From: Simon Davis
Sent: 14 September 2020 11:57
To: Kate Little [REDACTED]
Cc: Sam Pinkus [REDACTED]
Subject: RE: EV Charging - Yapton

**PLANNING LAYOUT  
70 UNIT SCHEME**

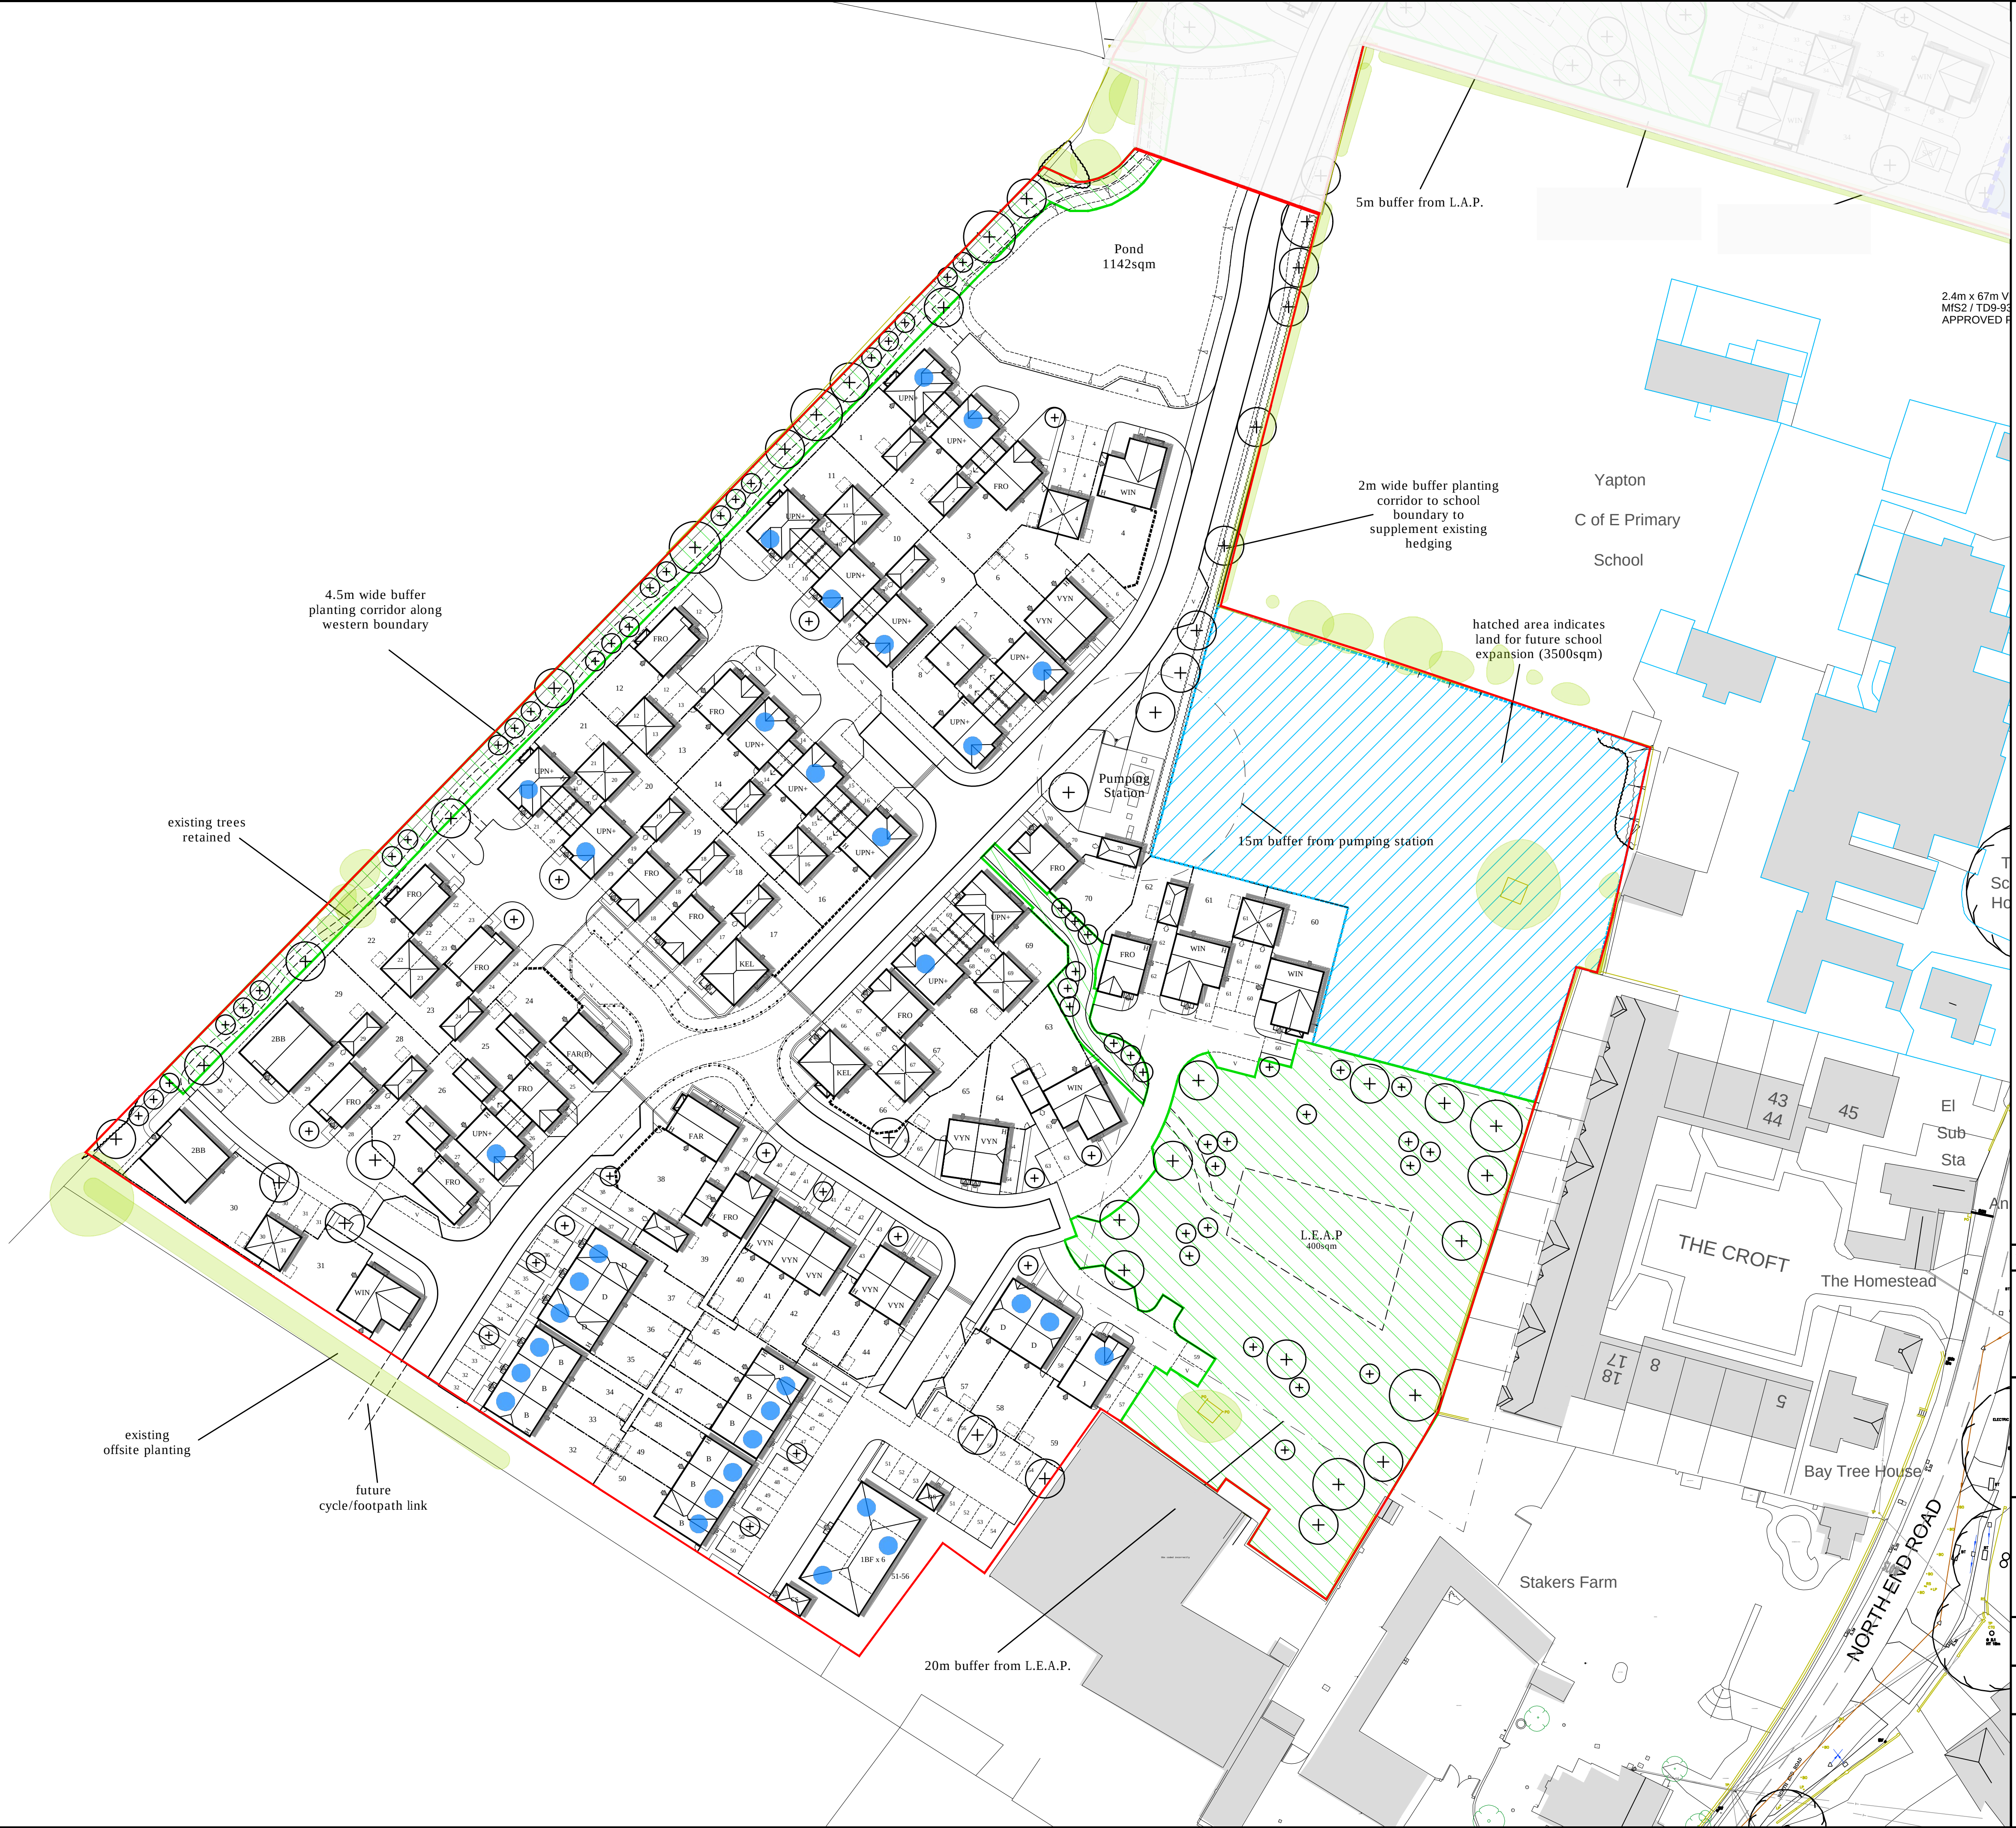
I am aware that you cannot propose works on land outside of your control. Looking at your plans, I am happiest with the connection at Stakers Farm although I think your road should not terminate at the boundary and it would be much better set in slightly with landscaping. Then you just need to ensure that the pavement/path on the northern side of the carriageway terminates at the boundary allowing access onto the private track. I would expect this path to be provided up to the boundary and finished level with the track. It should also be wide enough to allow cycle and pedestrian use.

It is not as clearly shown in the other site adjacent to Clays Farm. You have the link onto the existing PRow which runs inside your site and out towards the NW but it is not clear where or how there will be an access into Clays Farm. This should be along the same lines as for the one at Stakers.
